SUBJECT: Engineering Review Comment  
Mountain View Electric Association Inc. (The Association)

**Project Name: The Villas at Claremont Ranch – Final Plat**  
**Project Number: SF2228**

**Description:** Proposed development of 83 single family lots and 5 tracts located off Marksheffel Rd. and Meadowbrook Pkwy. in Township 14S, Range 65W, Section 04.

FINAL PLAT  
VILLAS AT CLAREMONT RANCH

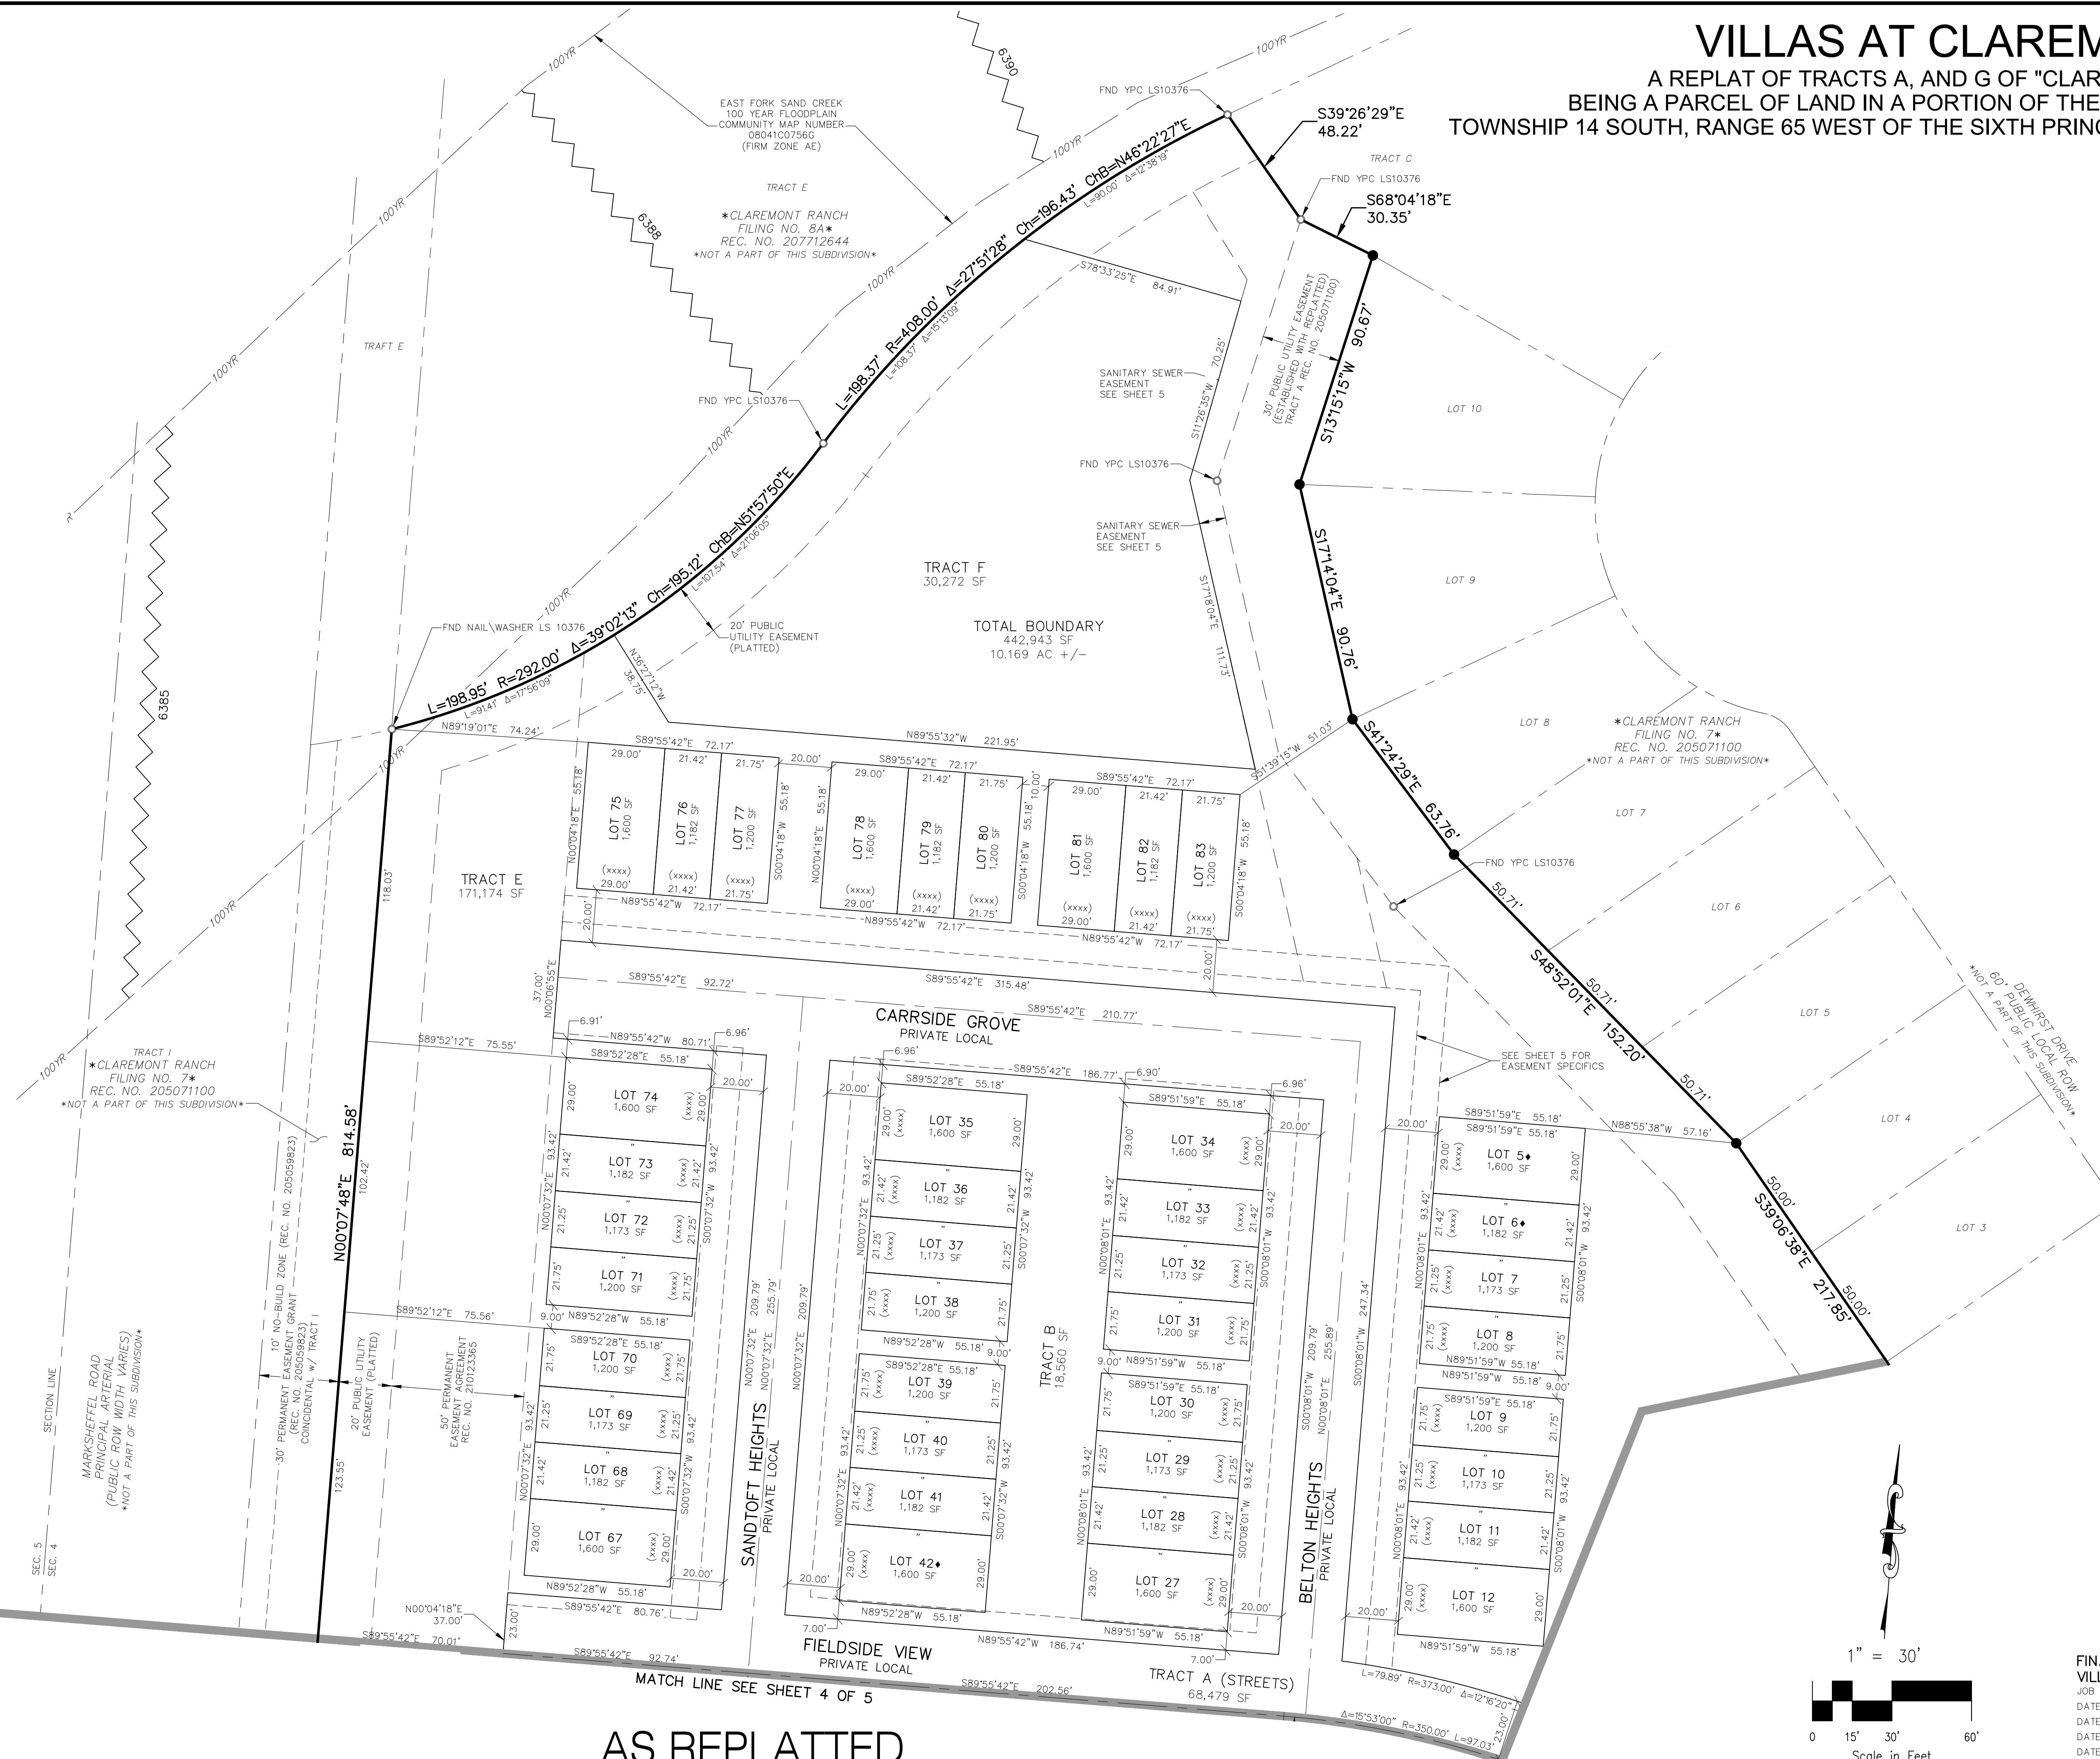
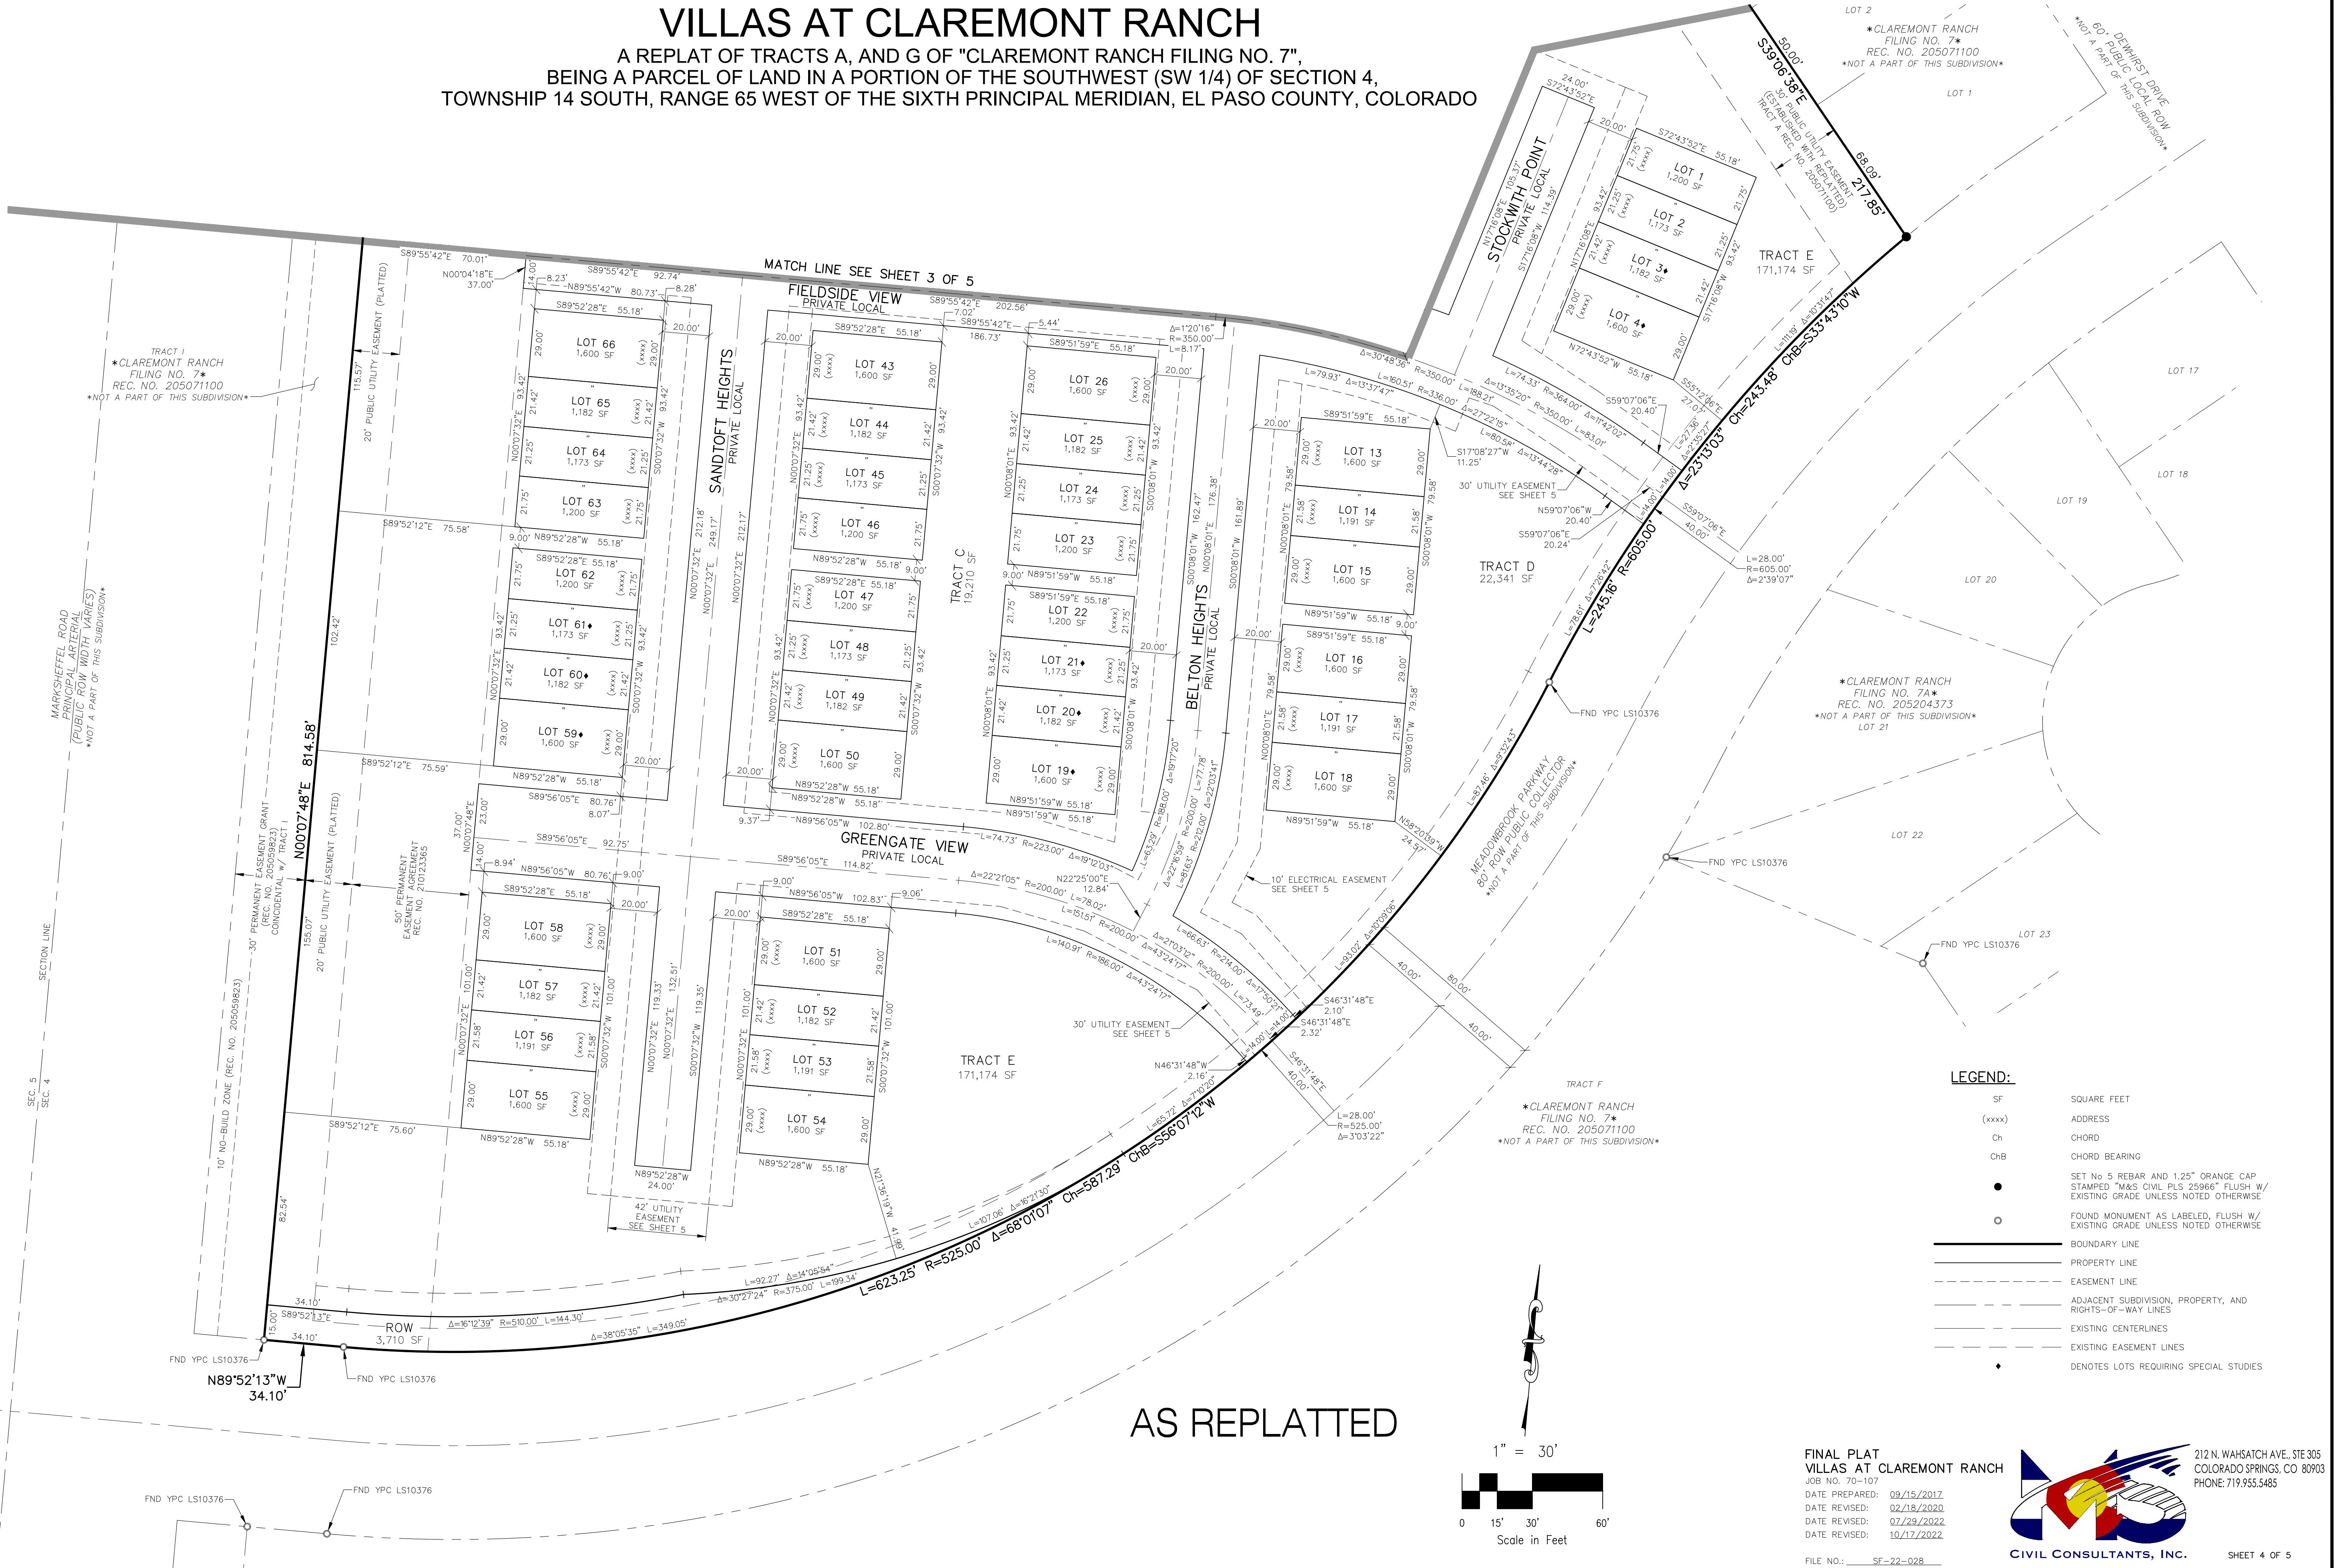
The Association requests a ten (10) foot easement behind all curb, all open spaces will be defined as a public utility easement, and a twenty (20) foot exterior boundary utility easement on the plat and all tracts. The Association also requests the platting of the Association's existing facilities with easements on the plat. Additional easements may be required.

10 foot easements adjacent to Tract A (private roads) and residential lots are labeled on sheet 5 of the plat.

No additional easements were added along the subdivision boundary, as such easements were previously dedicated by the plat of Claremont Ranch Filing No. 7, and remain in effect.

Other existing easements are shown and labeled.
